**BUCKINGHAMSHIRE COUNTY COUNCIL**

**COMMENTS ON THE EXAMINING AUTHORITY'S SECOND WRITTEN QUESTIONS**

**HIGHWAYS ENGLAND'S RESPONSE**

Drawing title  
SIDE ROAD PLAN & PROFILE  
REGULATION 4(2) (e)  
SHEET 13 OF 13  
OLD SLADE LANE

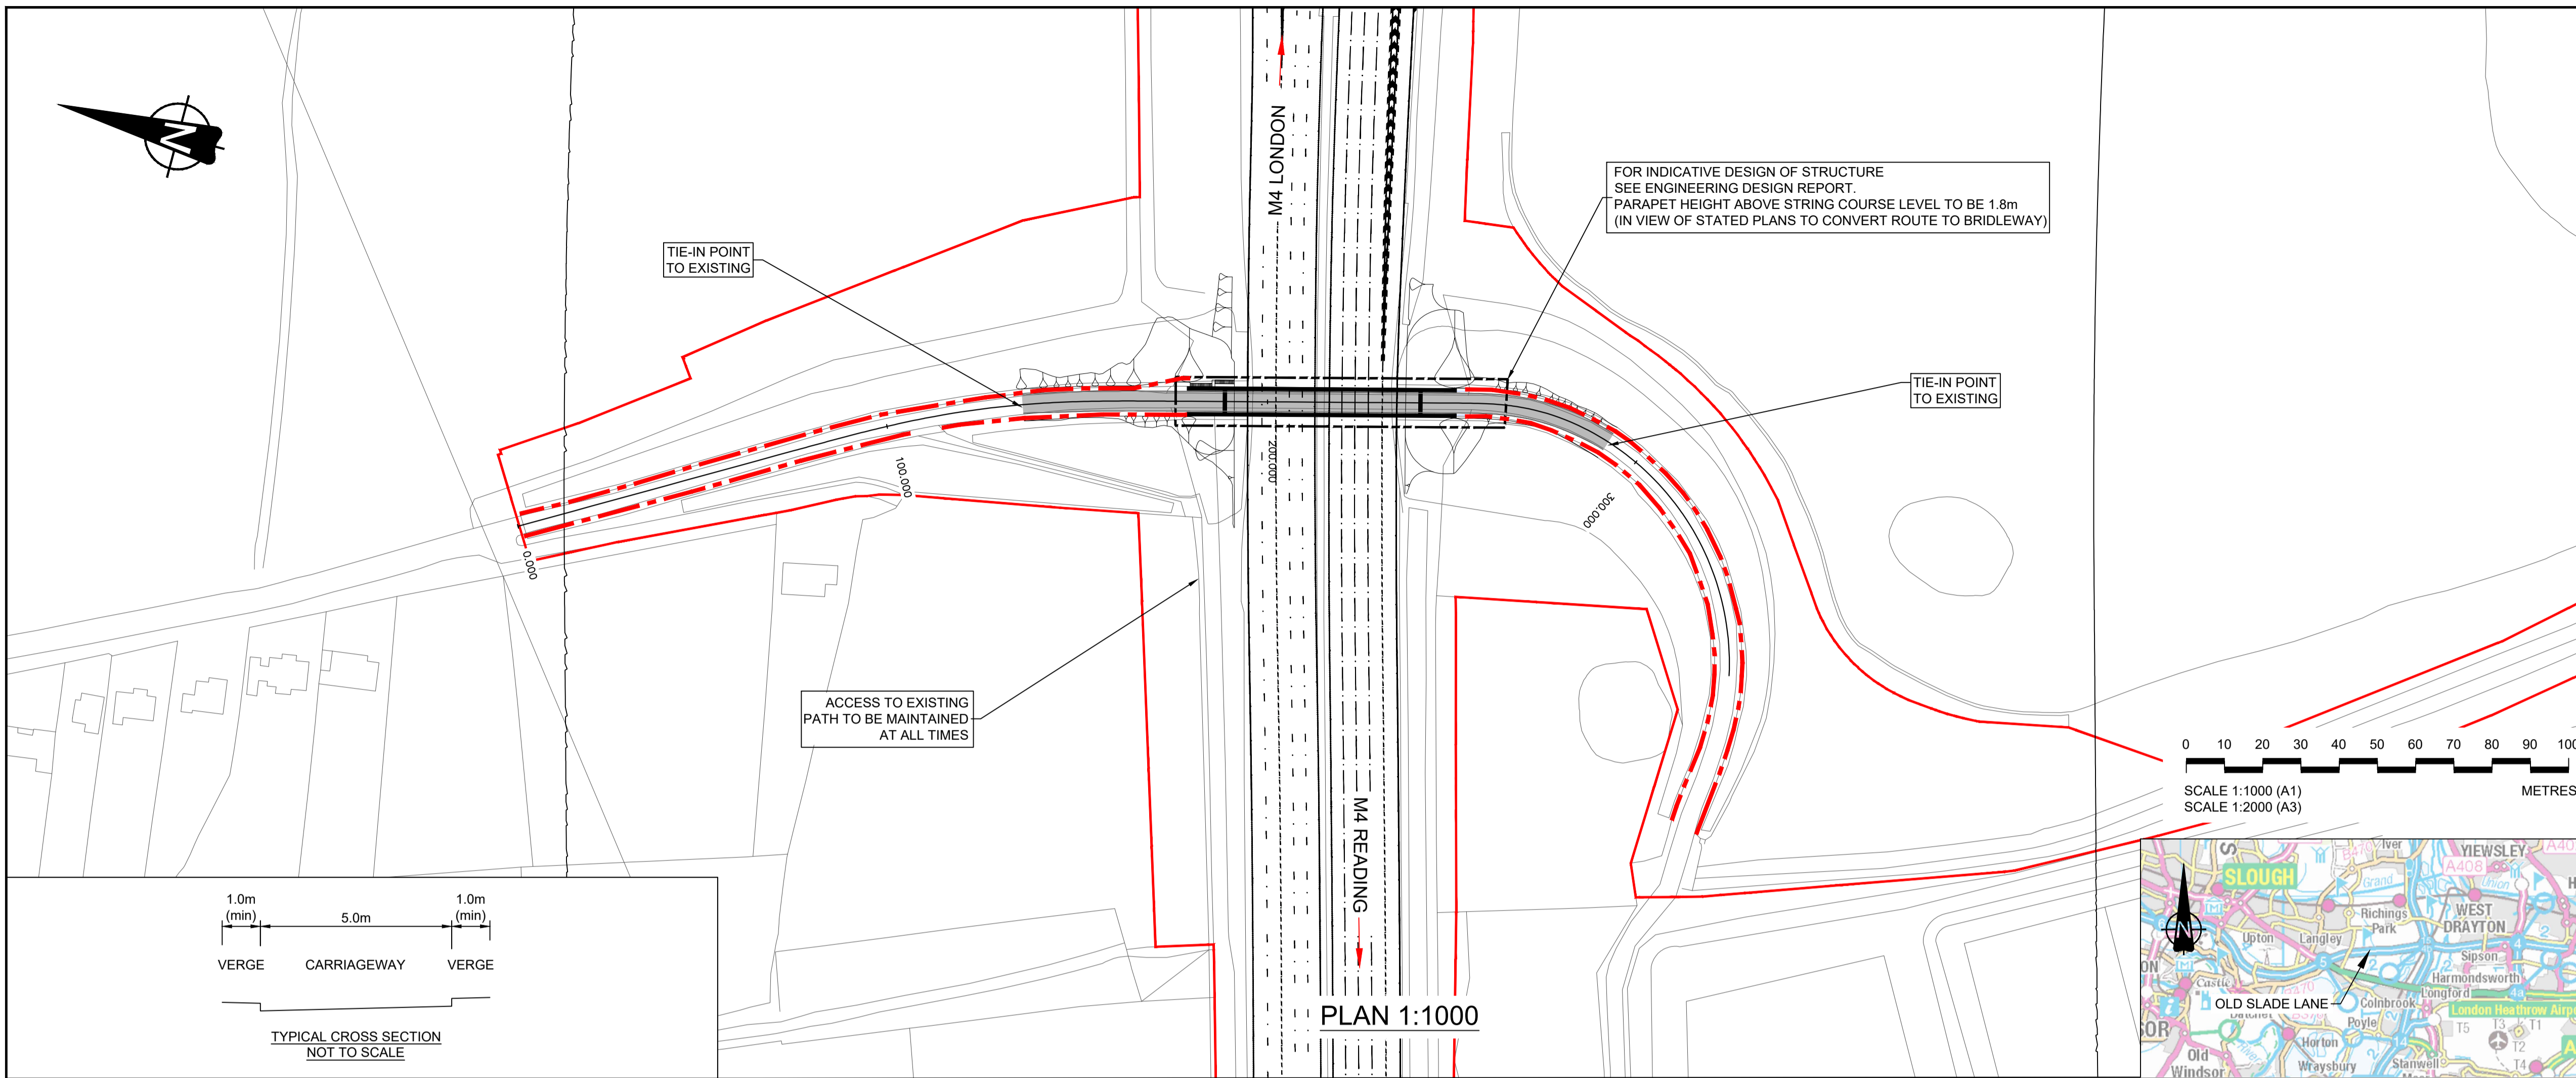
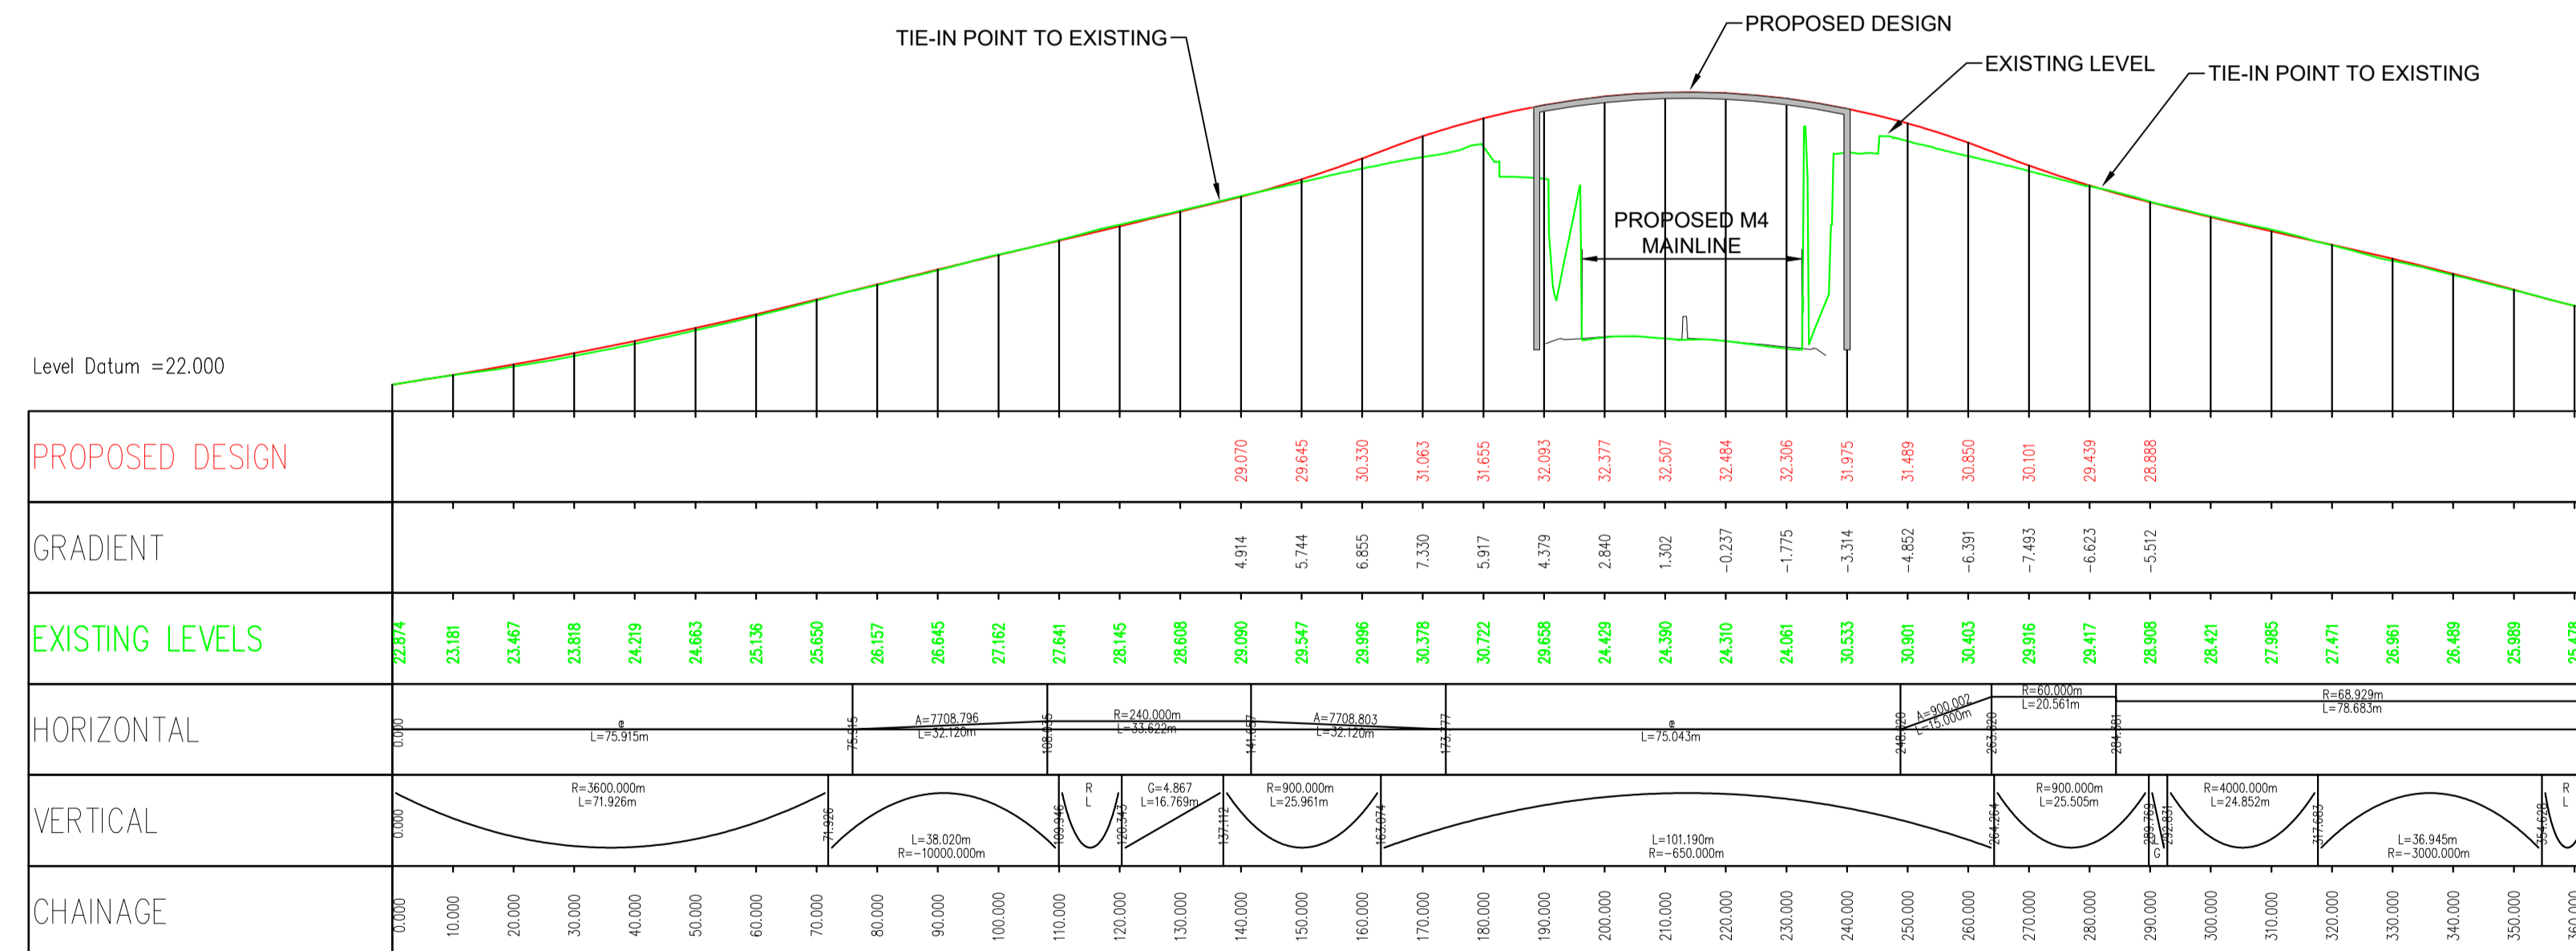
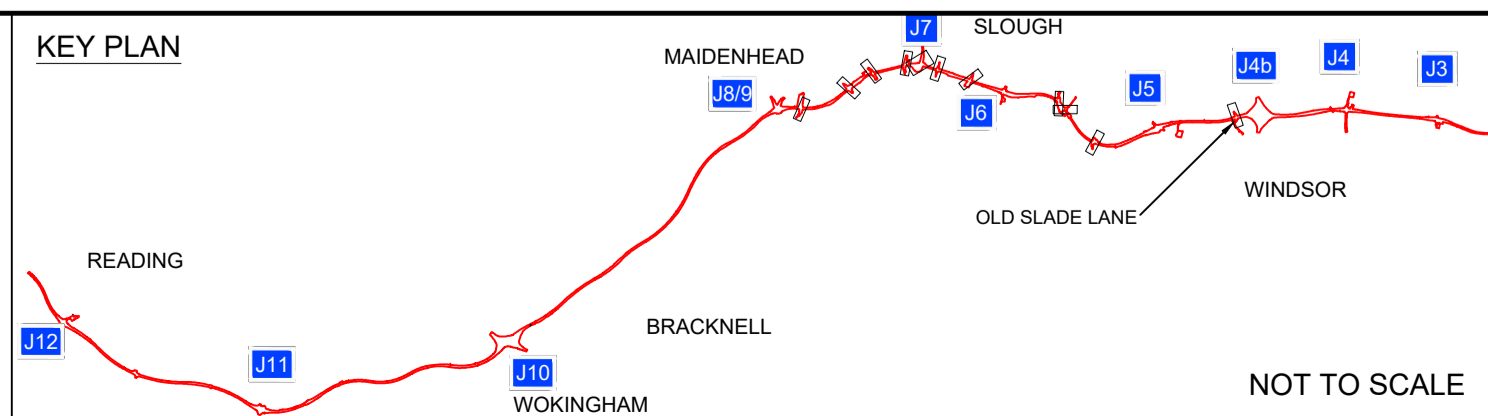
1.3.1 *Mitigation is sought for walkers, cyclists and equestrians unable to access the rights of way (ROW) network towards Colnebrook for a period of 12 months due to the closure of the Old Slade Lane overbridge. Users will be seeking suitable local alternatives on the north side of the M4 and these need to be in a condition to withstand the additional walking, cycling and horse riding traffic. Without viable alternatives this would lead to*

*a significant detrimental impact on the local RoW network and users thereof during the period of the temporary closure. HE have suggested an alternative route south via North Park, Sutton Lane, and Colnbrook bypass (A4), but this is largely unachievable and unrealistic due to the significant distance and unpleasant surroundings (noise and exhaust fumes). Without an attractive local network users will seek alternatives at honey pot sites (e.g. Burnham Beeches or Black Park/Langley Park), accessed in private cars, causing additional traffic delays.*

1.3.2 *The estimated total cost is £132, 700 for the NMU mitigation on the ROW network for the closure of the Old Slade Lane Bridge. Please see Appendix 2 for a map of the ROW route and the breakdown of mitigation costs.*

1.3.1.1 The Non Motorised User Survey Report (REP1-003) details low number of users of the Old Slade Lane public right of way (as shown in the extract from Table 1 of the report below).

1.3.1.2 The temporary closure of Old Slade Lane Bridge during its reconstruction will be inconvenient to those wishing to use the public rights of way. However, this has not been assessed as significant, given the low numbers of users, and availability of alternative direct routes in the area (even if possibly less attractive for leisure walking (depending on their origin)). Moreover, no evidence has been provided to the Examination which supports the contention that there will be effects at Burnham Beeches or Black Park/Langley Park (for example, even if 50% of users were diverted this would only represent approximately one user per hour at each site).

1.3.2.1 Given the low levels of current usage and the availability of alternatives, no further mitigation to that detailed in the Environmental Statement is considered proportionate or appropriate. Moreover, the proposed improvements are outside the Order limits of the Scheme.

1.3.2.2 Further, Highways England disagrees as to the suitability of the alternative public right of way suggested in terms of use by equestrians and in terms of the potential security issues when passing through the M25 underbridge. These are detailed in photo 3 in Appendix 2 of BCC’s submission (REP5-009), which shows that the suggested public right of way is secluded and in a dark location with visible graffiti and low headroom.
